Department of Transportation

October 16, 2018

RE: Appaloosa - VR1813, Vacate and Replat of the I-2 (Limited Industrial) site, Revised 10/16/18

2 of 6

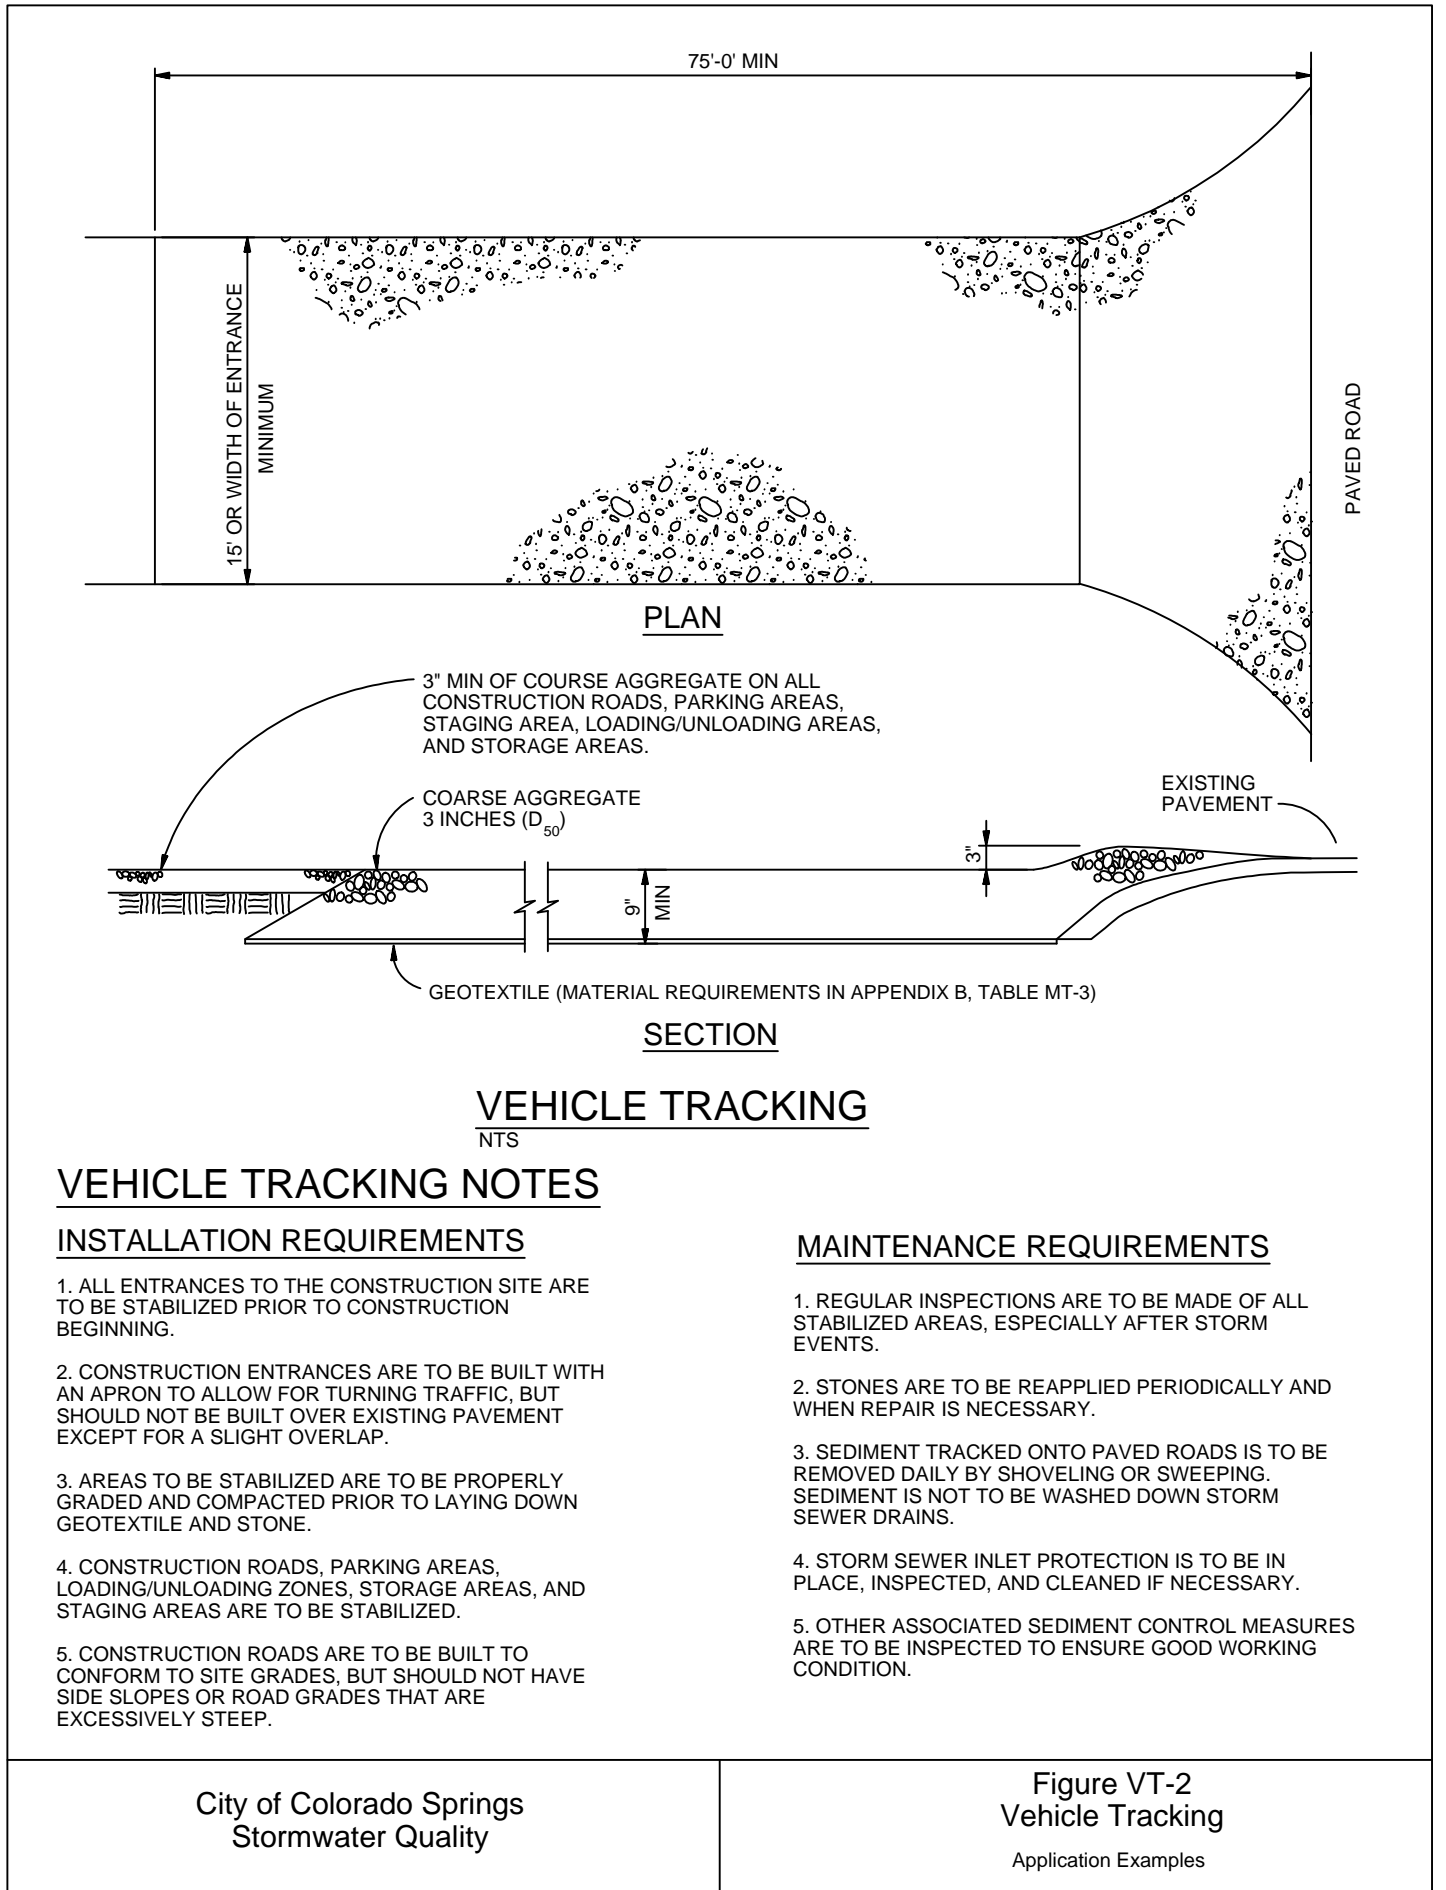
- The development is following the water quality and detention requirements set forth by the Colorado Springs Drainage Criteria Manual.
- They are also replacing a portion of a concrete channel that looks to be failing within a Zone AE floodplain along the eastern edge of the property. I'm assuming they are working with the City's floodplain manager on this portion of the project. There is no hydraulic information for this channel within the report, but they are simply replacing the channel in kind. These improvements shouldn't change the hydraulics for the culvert under SH 24.
- Please provide riprap from the site outlet all the way to the existing CDOT culvert apron.
